Item No. **Report of the Head of Planning, Transportation and Regeneration**

Address 18 LINKSWAY NORTHWOOD

Development: Erection of a detached 7 bed dwelling with basement and habitable roof space to include 4 rear dormers including demolition of existing dwelling, replacement new wrought iron gates and piers and removal of the front boundary brick walls

LBH Ref Nos: **2695/APP/2021/466**

rev.	date	description
scale:	1: 100	A0 date: 12 / 01 / 2021
drawing no:	1366 / P / 10	drawn: FJ
drawing:	PLANNING PROPOSALS COMPARISON PLANS	
project:	LAND AT 18 LINKSWAY, NORTHWOOD, MIDDLESEX, HA6 2XB	
client:	DDA

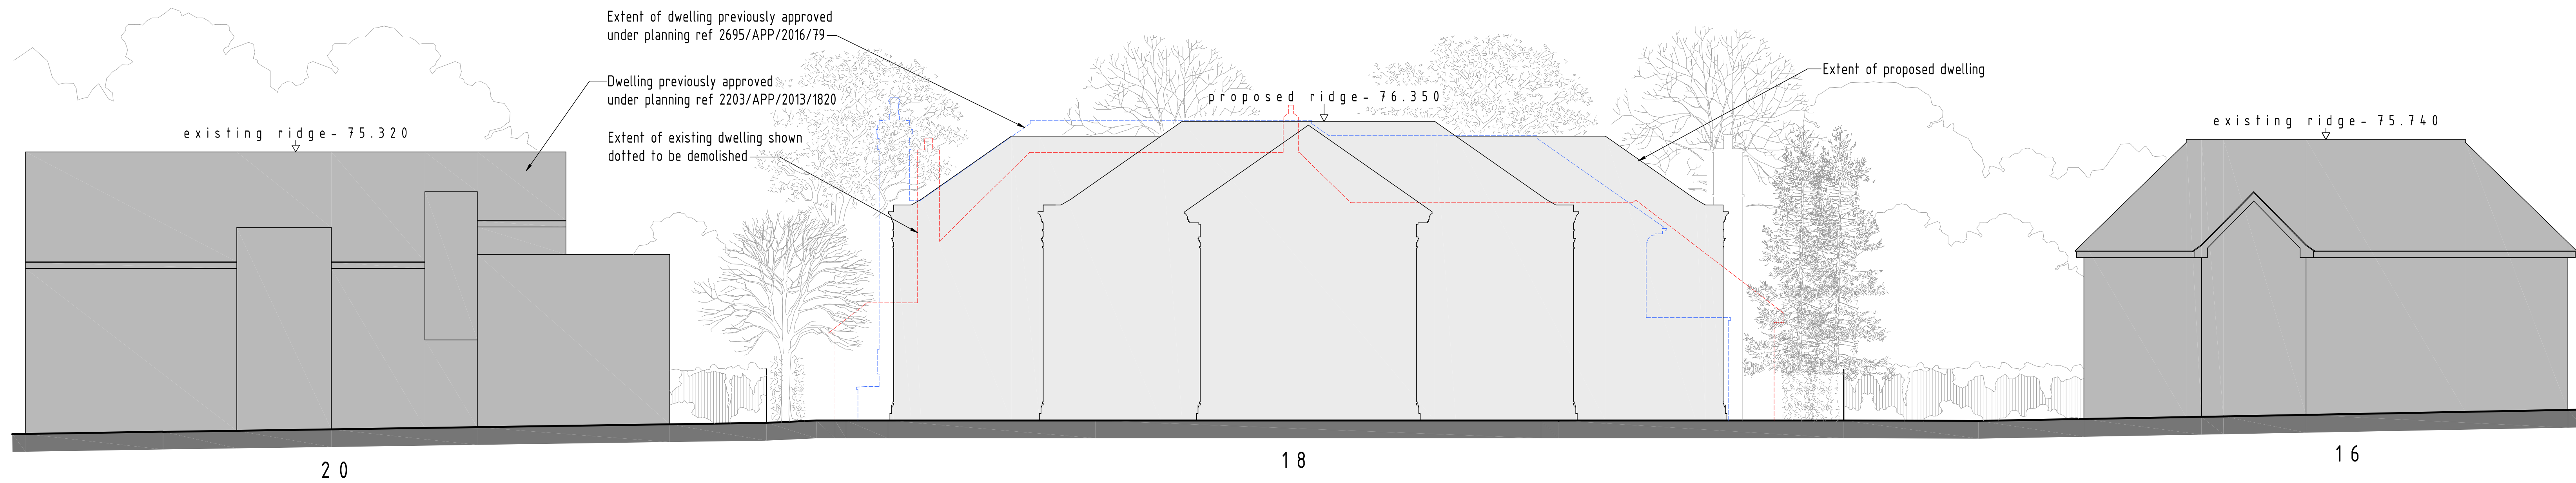
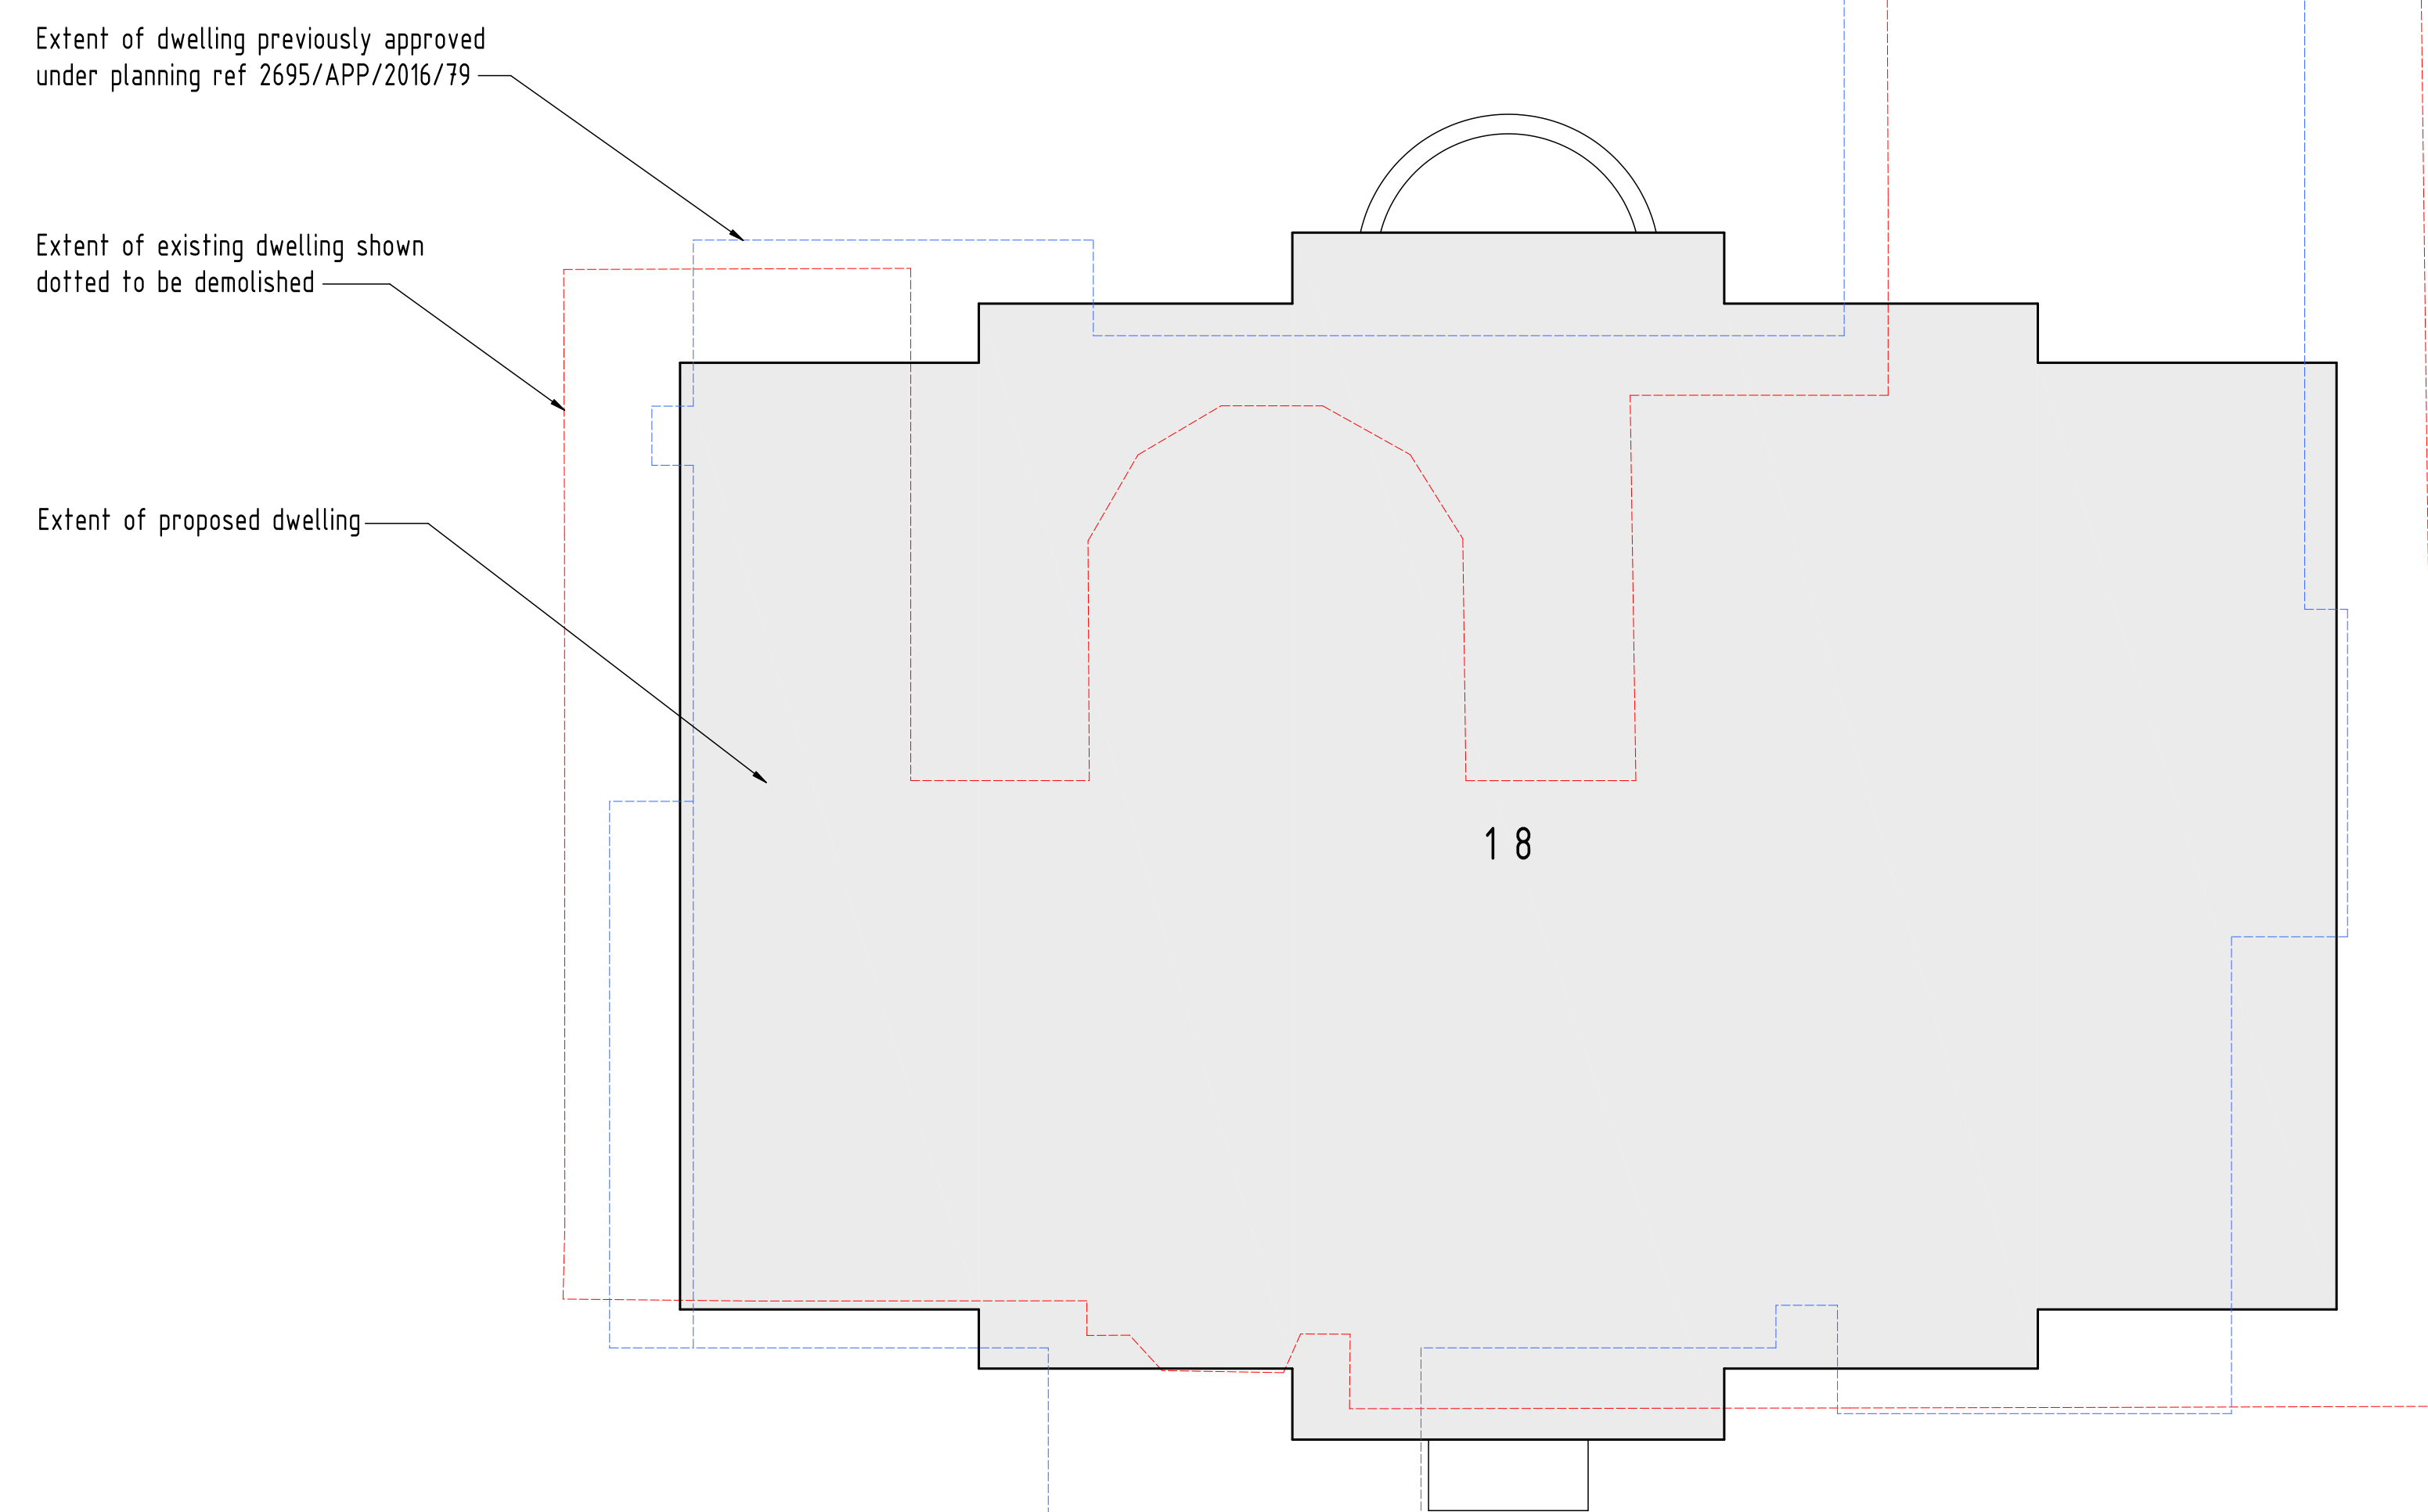
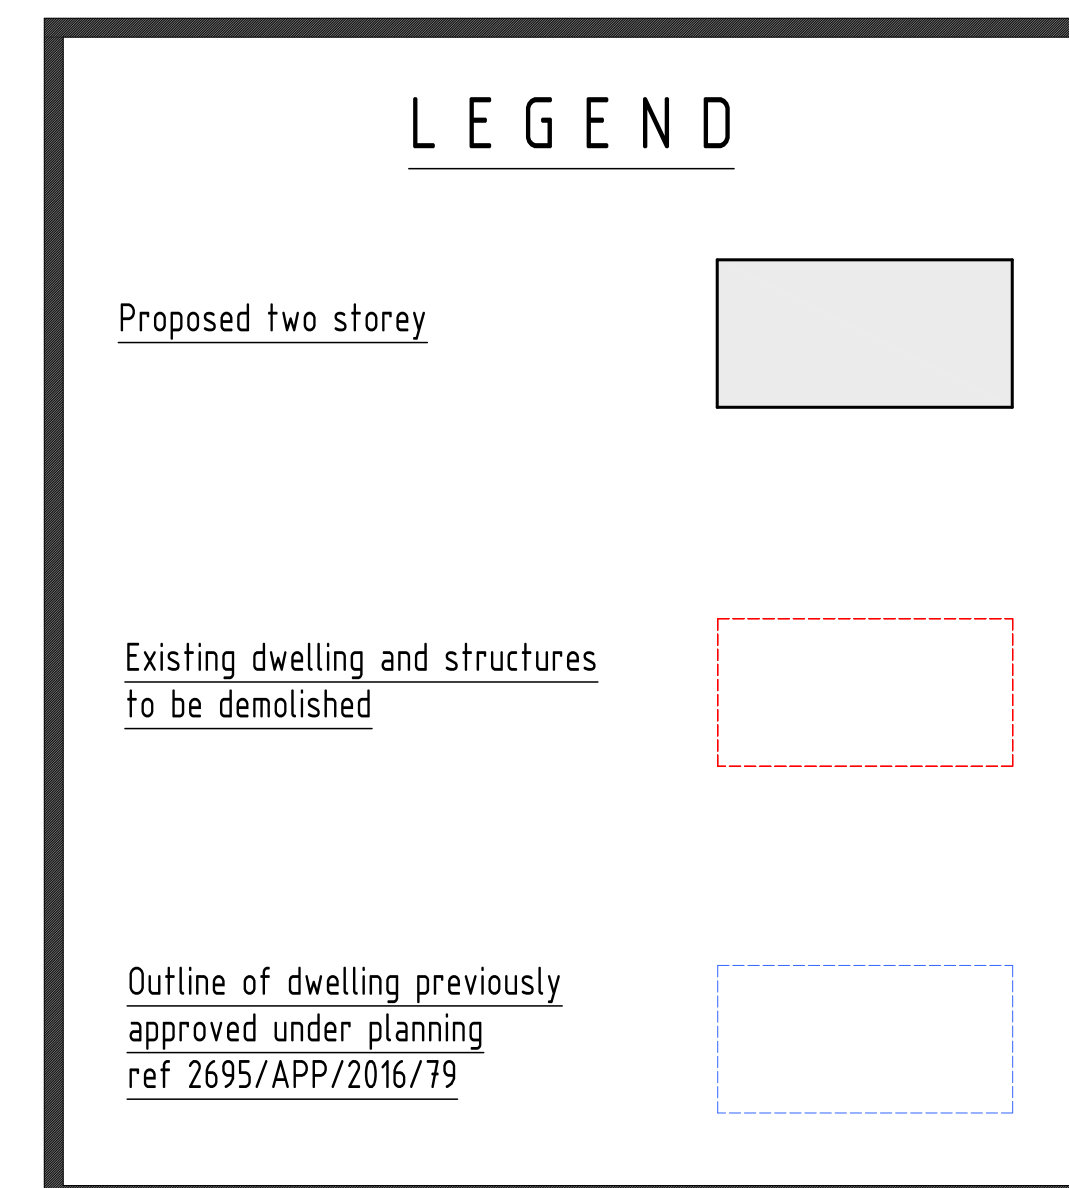
The proposed development would extend across the great width of the site with small gaps retained along the side boundaries. Whilst the footprint may be slightly smaller than the existing building, the scale and bulk of the built form is vast and further accentuated by the design and detailing of the building. The proposed columns elongate the height of the building and the large crown roof exacerbates the bulk of the development.

This application relates to the erection of a seven-bedroom detached house, comprising habitable loft accommodation and a basement. The property measures a maximum of 28m in width and 20.45m in depth, set beneath a large crown roof of 10.1m in height.
